From: Ian Hayward [REDACTED]
Sent: 13 February 2020 08:41
To: Simon Davis <Simon.Davis@arun.gov.uk>
Subject: RE: BN/6/20/PL Cottage Piggeries

Essentially, in this case the dwelling and garage accommodation can be treated as a 4+ bed dwelling.

It is proposed to provide a double garage and hardstanding to accommodate the parking demand.

Proposed Ground Floor Plan

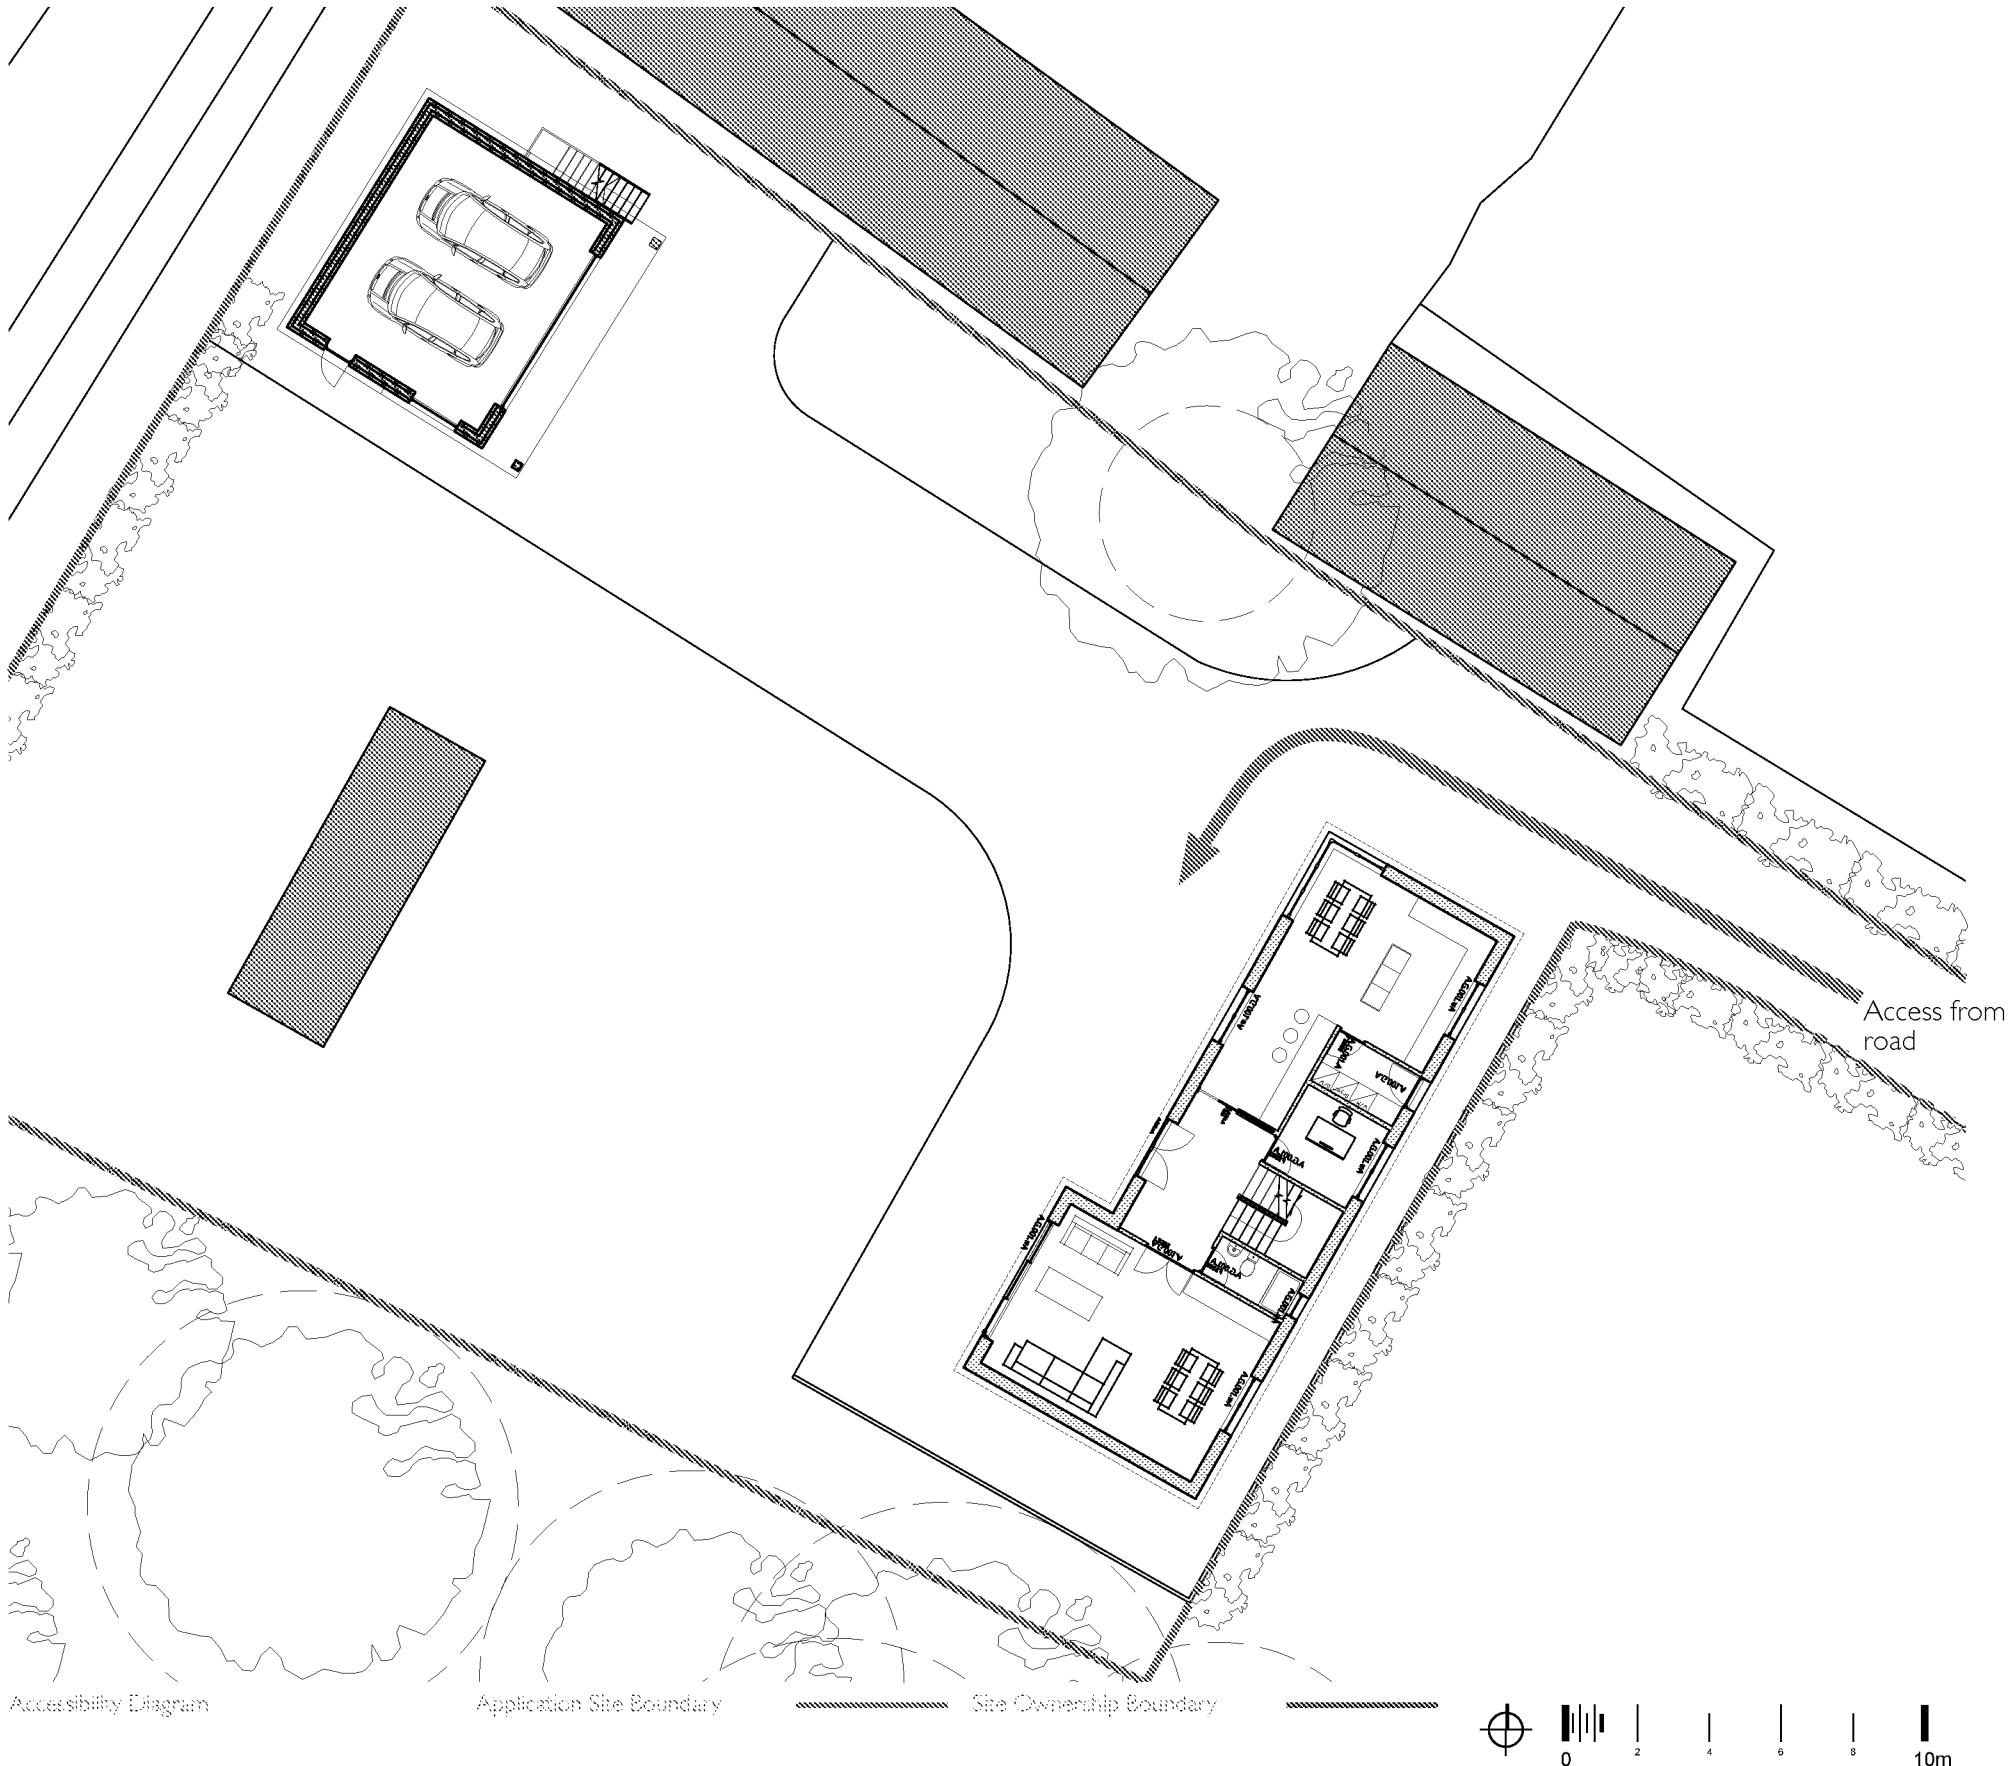
The garage scales to 7.5 x 6.4 metres internally, which equates to two spaces, however the Arun DC Parking SPG considered each garage space to accommodate 0.5 of the parking demand. Therefore, the surrounding hardstanding areas should be large enough to accommodate 4 vehicles. Based on the site plans provided this can easily be accommodated without prejudicing the ability for vehicles to turn on site. Given individual car parking spaces have not been demonstrated you may wish to consider the amenity implications of this or request the applicant demonstrate the spaces and allocation of spaces on the site plan. The suggested condition below seeks to obtain these specific details prior to occupation, though you and the applicant may prefer to have this demonstrated prior to determination.

Cycle parking can be accommodated within the garage facility; it would be beneficial if the replacement caravan can be provided with an independent cycle storage provision. A suggested condition has been provided below to cover this.

No part of the development shall be first occupied until the car parking spaces have been constructed in accordance with plans and details to be submitted to and approved in writing by the Local Planning Authority. These spaces shall thereafter be retained at all times for their designated use.

No part of the development shall be first occupied until covered and secure cycle parking spaces have been provided in accordance with plans and details to be submitted to and approved by the Local Planning Authority.
